EPC STORMWATER REVIEW COMMENTS
IN ORANGE BOXES WITH BLACK TEXT

FINAL PLAT ACADEMY GATEWAY SUBDIVISION FILING No. 2

A REPLAT OF TRACTS C, D & E, ACADEMY GATEWAY SUBDIVISION FILING No. 1
LOCATED IN A PORTION OF THE SOUTHEAST QUARTER OF SECTION 1, TOWNSHIP 12 SOUTH, RANGE 67
AND THE SOUTHWEST QUARTER OF SECTION 6, TOWNSHIP 12 SOUTH, RANGE 66, ALL WEST OF THE 6TH P.M.,
EL PASO COUNTY, COLORADO

REVISIONS:	PROJECT No.	24213
	DATE:	FEBRUARY 20, 2025
	DRAWN BY:	JMJ
	CHECKED BY:	MSJ
	SHEET:	1 OF 3

AS PLATTED - PLAT #13997

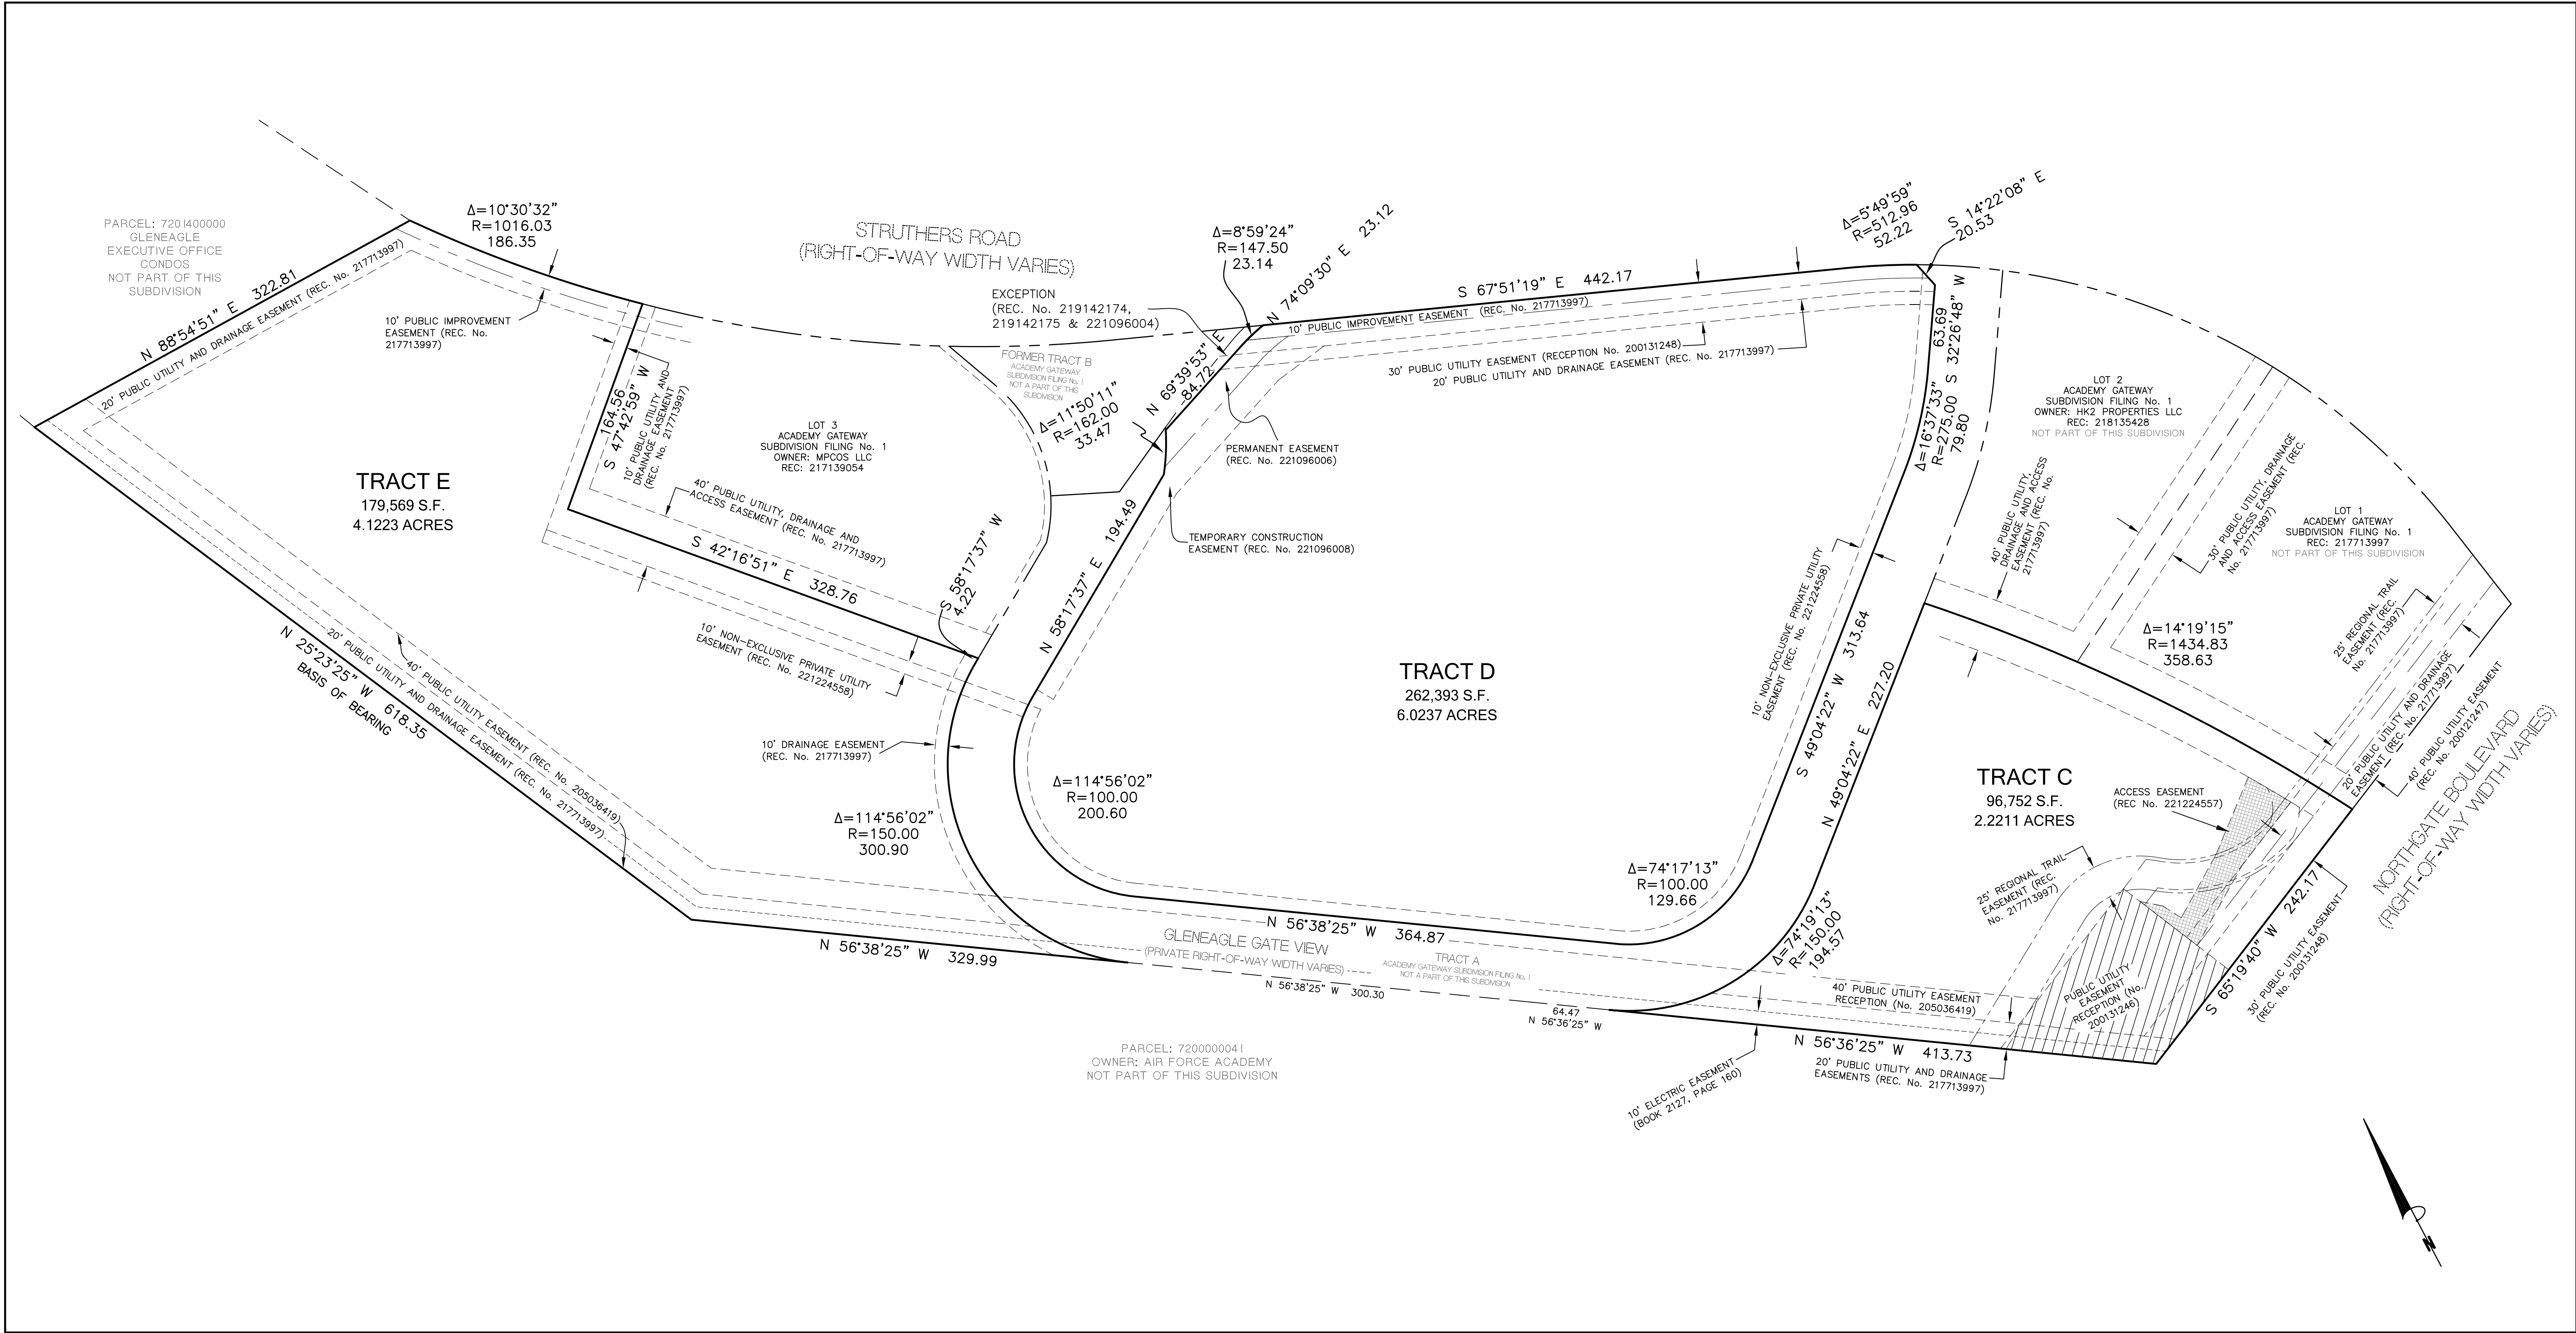
AS PLATTED Add Plat # 13997 ✓
